## **The North Yorkshire Council**

### **The Council's response to the Examining Authority Written Questions for Deadline 6**

Drawing Title: Classification of Roads Plan Regulation 5(2)(o) Sheet 1 of 2

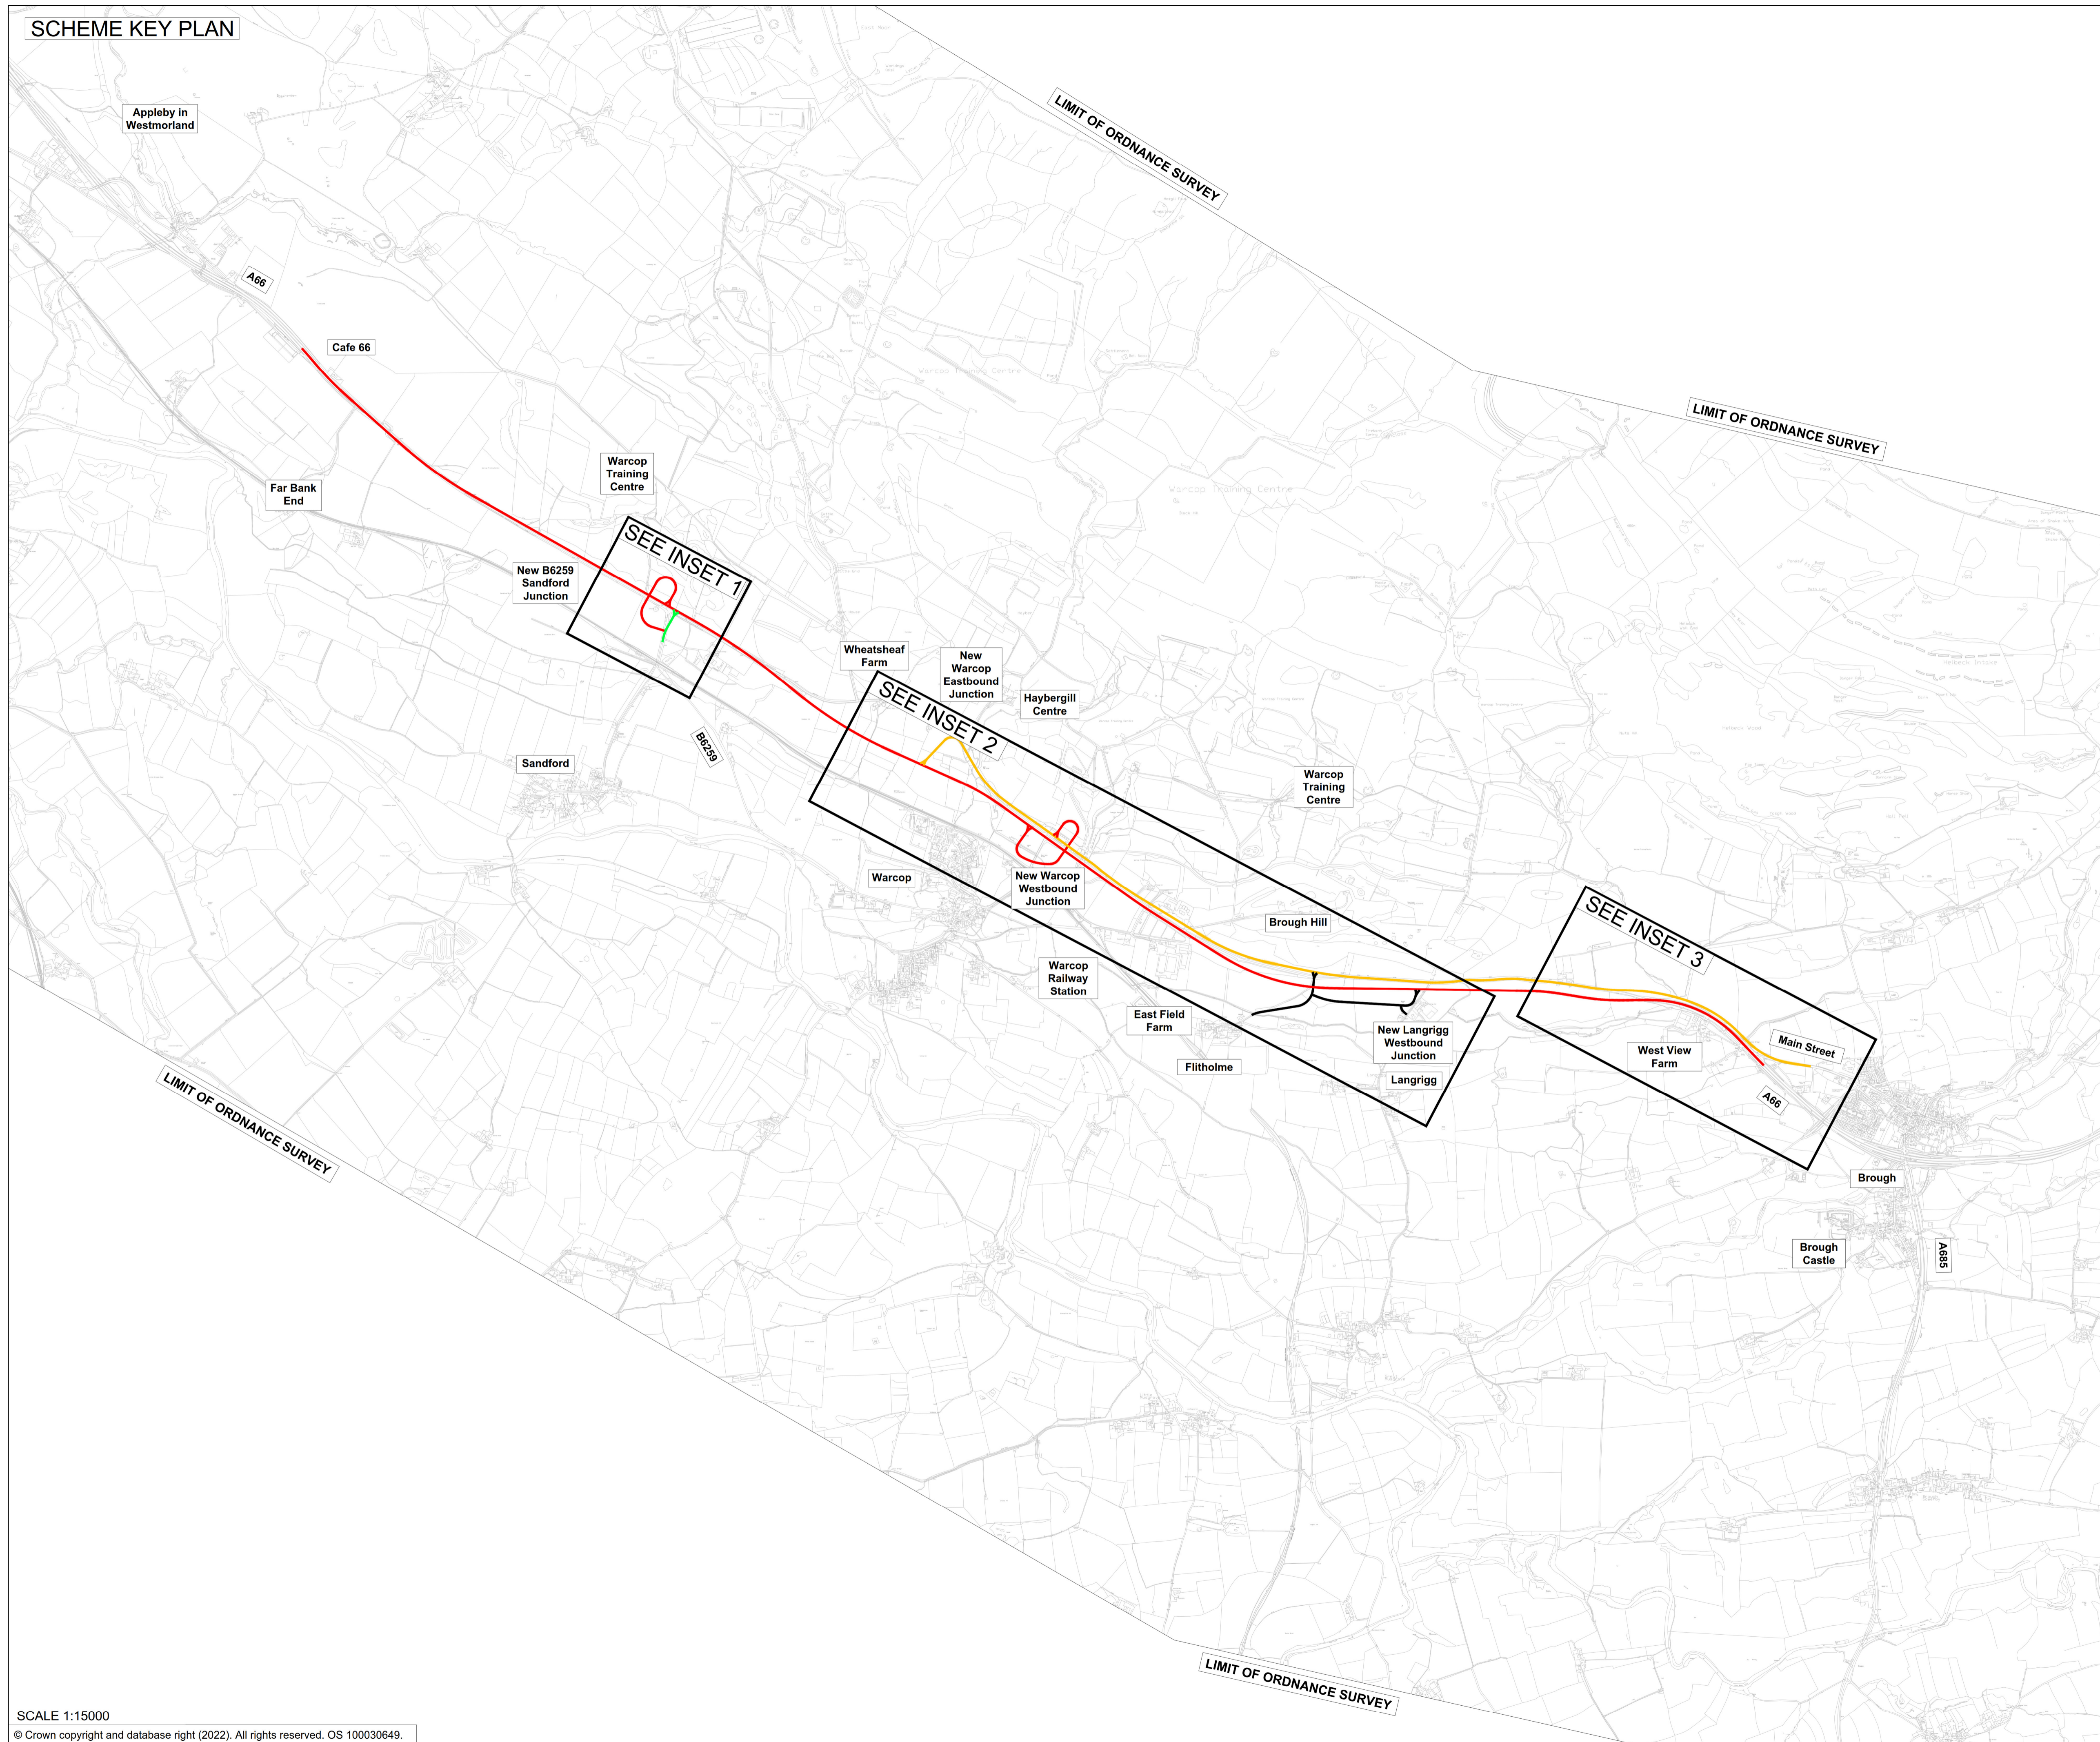
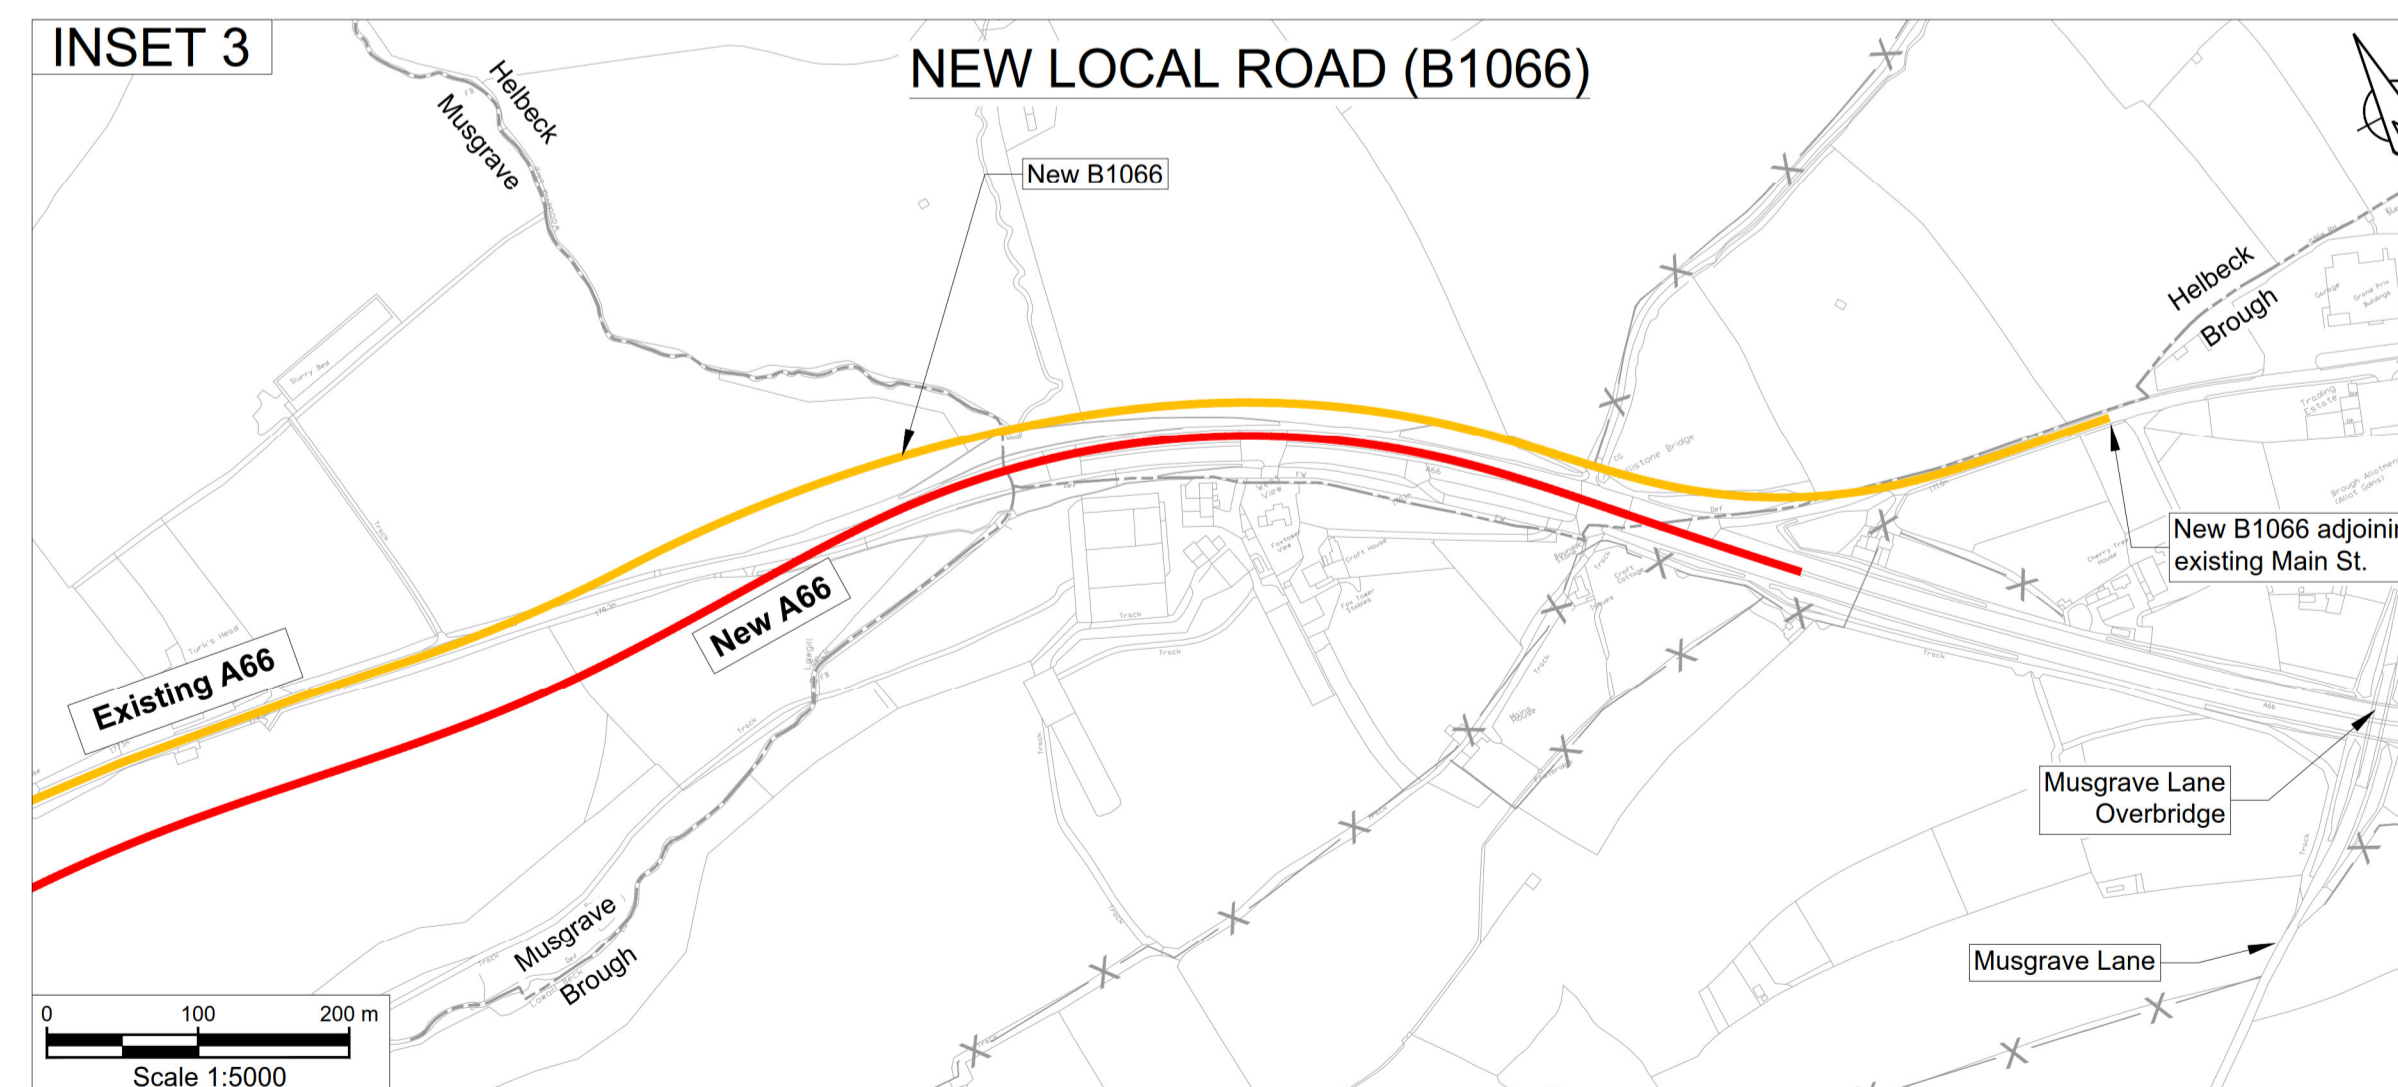
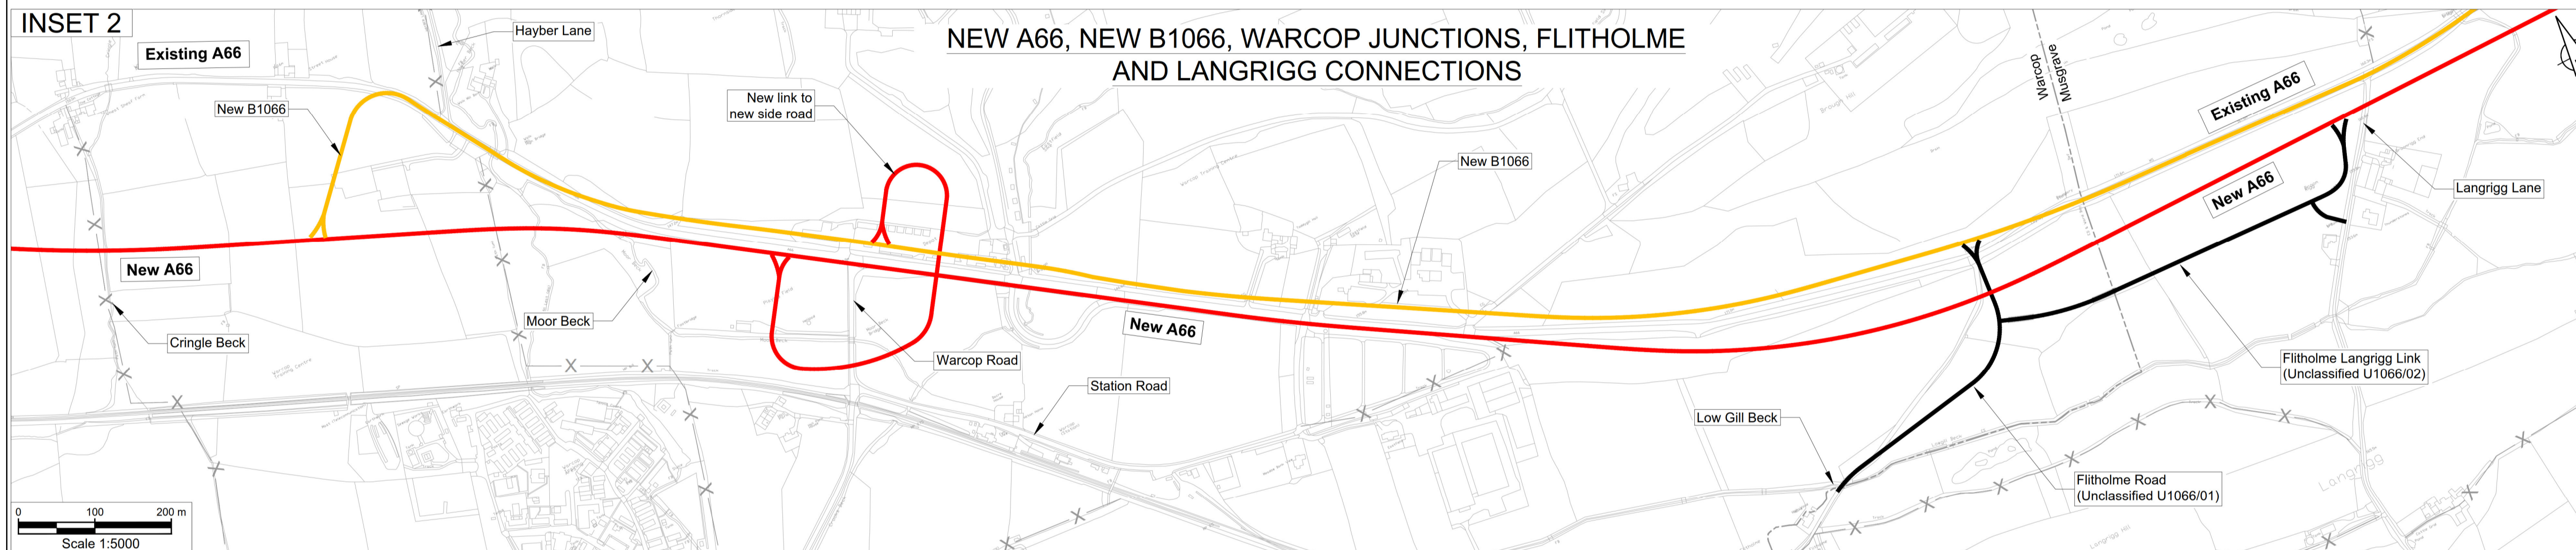
<b>DCO 2.3</b>	Schedules 2 and 7	The Applicant	In its response [REP1-005] to the ExA's Supplementary Agenda Additional Question ISH2.DCO.18	The Council confirms that until the DCO is made and the detailed design of the local road network is complete the dDCO should indicate the classification number for de-trunked sections to be TBC.

Reference No	Subject	Response by	Question	Councils' further comments
			<p>[EV-004], the Applicant suggested that the classification number to the de-trunked section of the A66 should be unique and is under discussion with Cumbria CC. The latest draft DCO [REP5-012] still refers to the B1066, which is not a unique classification number. Explain why this has not been amended.</p>	
<b>GM 2.1</b>	SOCGs	<p>The Applicant All relevant parties</p>	<p>Table 4.1 of the Statement of Commonality for SoCGs [REP5-003] sets out the position of each SoCG between the Applicant and the relevant Interested Party. The Applicant is requested to update the table setting when it expects the final and signed SoCG will be submitted into the Examination. Interested parties who disagree with their respective draft SoCGs are requested to inform the ExA at Deadline 6, Tuesday 04 April 2023.</p>	<p>There are no fundamental disagreements, and the Council is confident that for those matters not resolved we can agree with the Applicant mutually acceptable responses for the final SOCG and PADSS.</p>
